Appeal Decision

Appeal Ref: 6002695

96 Oakdene Road, Uxbridge, Hillingdon UB10 0SQ

- The appeal is made under section 78 of the Town and Country Planning Act 1990 (as amended) against a refusal to grant planning permission.
 - The appeal is made by Mr Singh against the decision of the Council of the London Borough of Hillingdon.
 - The application Ref is 17448/APP/2025/2373.
 - The development proposed is conversion of roofspace to habitable use to include a hip to gable roof extension, rear dormer and 3 front rooflights, single storey rear extension and change of use to 5bedroom 5person HMO. (Part retrospective).
-

DRAWING
TITLE: **PROPOSED DRAWINGS**

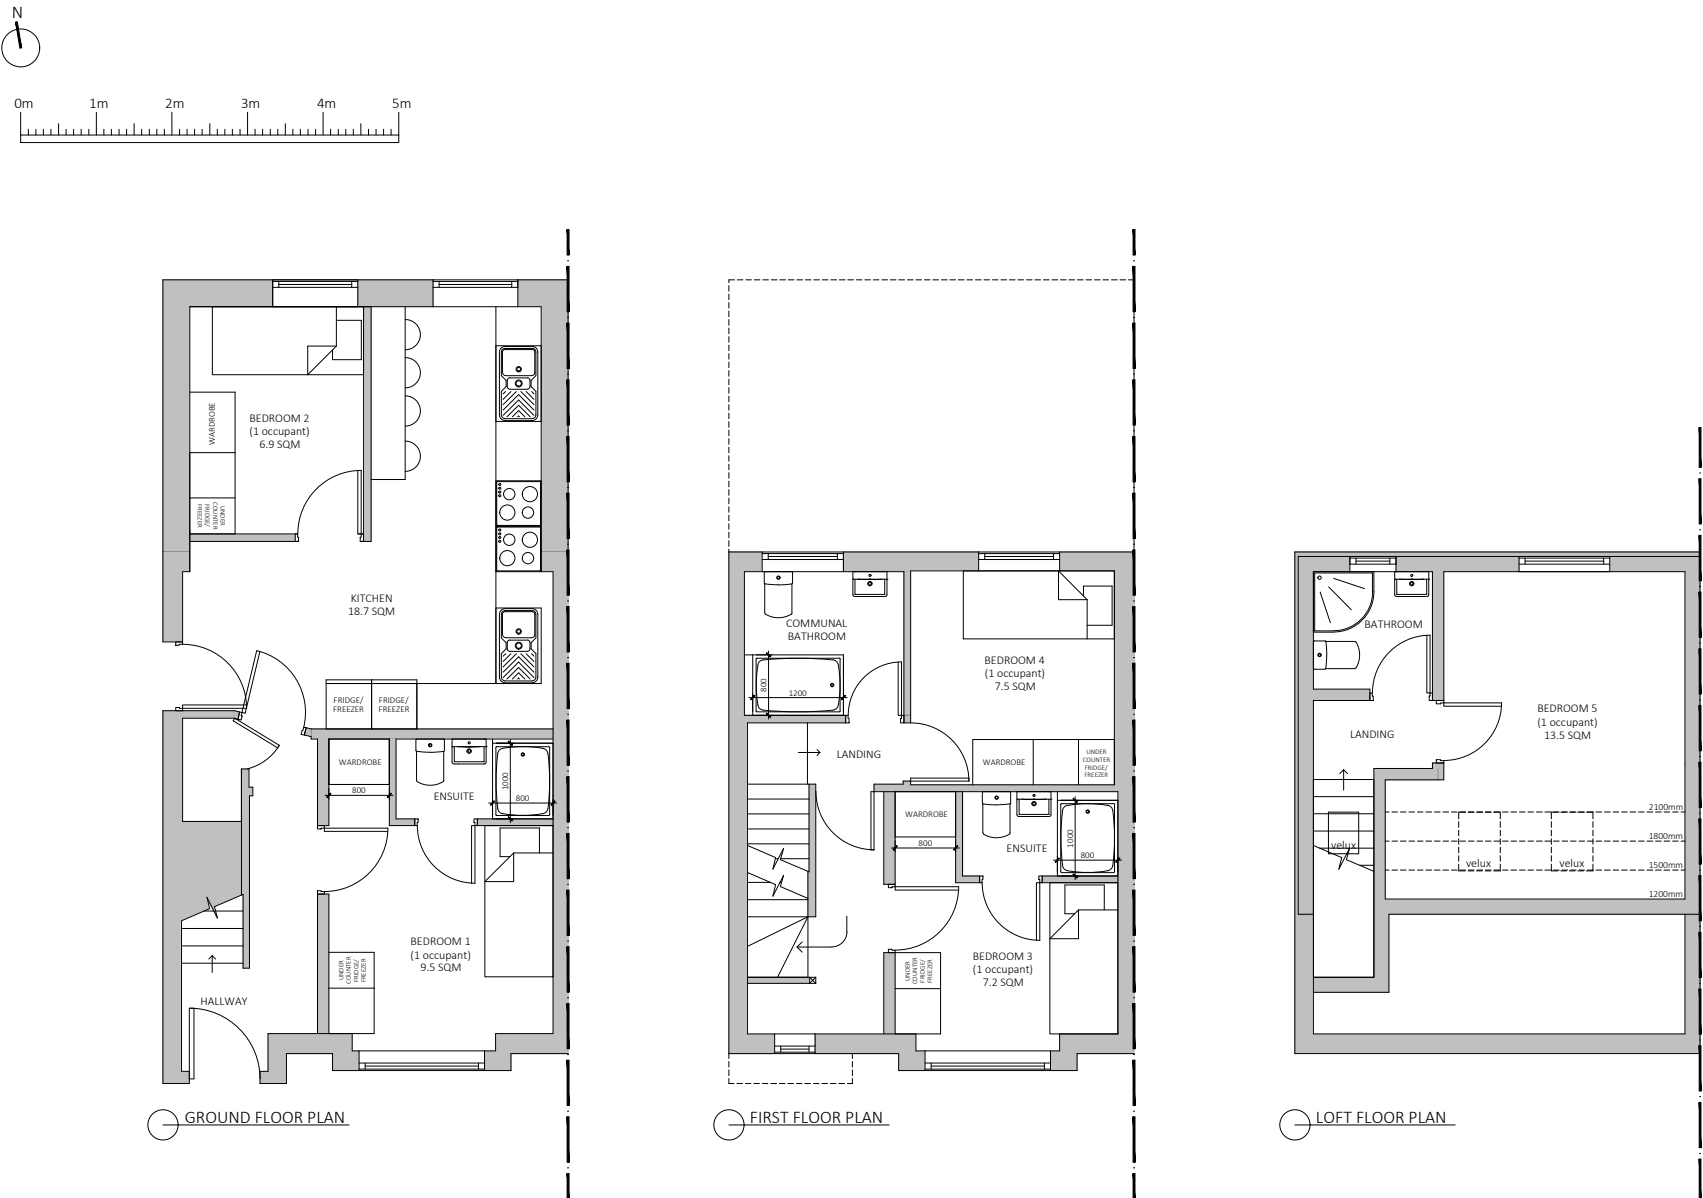
2. The application form states that the development has begun. However, the development as built diverges from the plans before me at the rear elevation, where the single storey extension has 2 sets of doors and 1 small window, instead of 2 windows as shown in the plans. For clarity, I have assessed the appeal against the submitted plans and evidence, rather than what has been constructed to date.

5. The proposal would introduce a gable-end roof which would unbalance the harmonious symmetry of the short terrace. This would sit in marked contrast to the hipped roof at the adjoining terrace and to the roof forms found in surrounding development, resulting in an incongruous appearance in its context. Whilst there may be some examples of similar roof extensions on surrounding streets those are not viewed within the same streetscene context as the proposal, and so do not justify the resulting harm.

6. The proposed rear dormer window would occupy almost the entire rear roof slope, with only a minor offset from the ridge, eaves and side wall. This would result in an over-dominant effect on the appearance of the building. The use of matching materials would not overcome the harm arising from the introduction of the alien roof form and dominant addition to the rear roof slope.

11. The proposal would also involve new ground floor and loft level bedrooms located along the wall shared with the attached neighbouring dwelling. Whilst communal space is proposed for occupants, this would be limited in size and centred on kitchen and dining facilities. Consequently, individual occupants would be likely to

17. The plans indicate that 1 parking space would be provided in the front yard, although a dropped kerb access to that space is not indicated. Even if I were to accept that on-site provision of 1 space, a shortfall of 2 spaces would remain. There is no controlled parking zone in operation in this location, but I am mindful that on-street parking on Oakdene Road is limited by existing dropped kerbs. Consequently, the proposal would likely contribute to unacceptable pressure on the availability of on-street parking in the vicinity of the site.
